# Permit Reviews Harnett County

Permit Number: **BRES2310-0010**

Description: **14x66**

Site Address: **371 FAMILY LN**

PRELIMINARY HOUSE LOCATION FOR  
**SANTIAGO CHAVEZ AVILA &  
RACIEL RIVERA CRUZ**

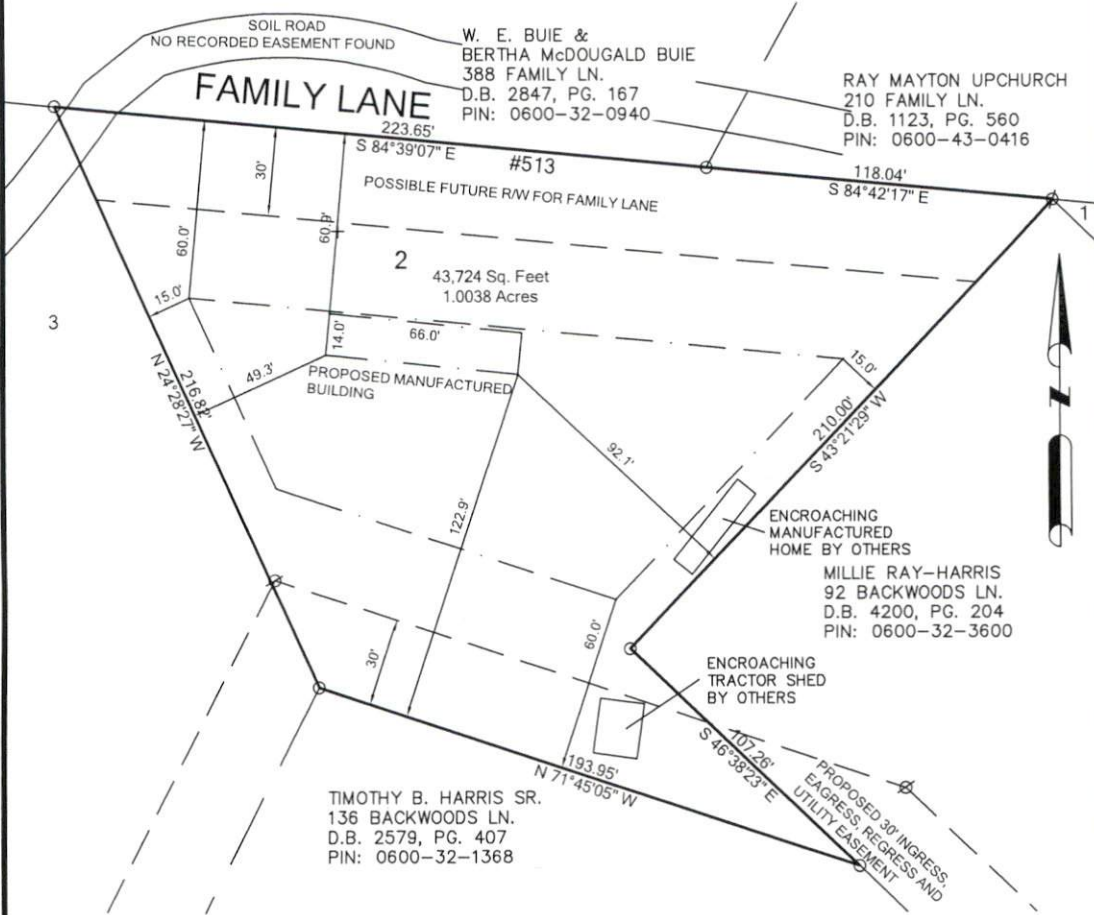
| SENT DATE  | RETURNED DATE | DUE DATE   | TYPE          | CONTACT      | STATUS       | REMARKS |
|--|---------------|------------|---------------|--------------|--------------|---------|
| Need house accurately staked off, and backhoe pits will be required to evaluate the soil |               |            |               |              |              |         |
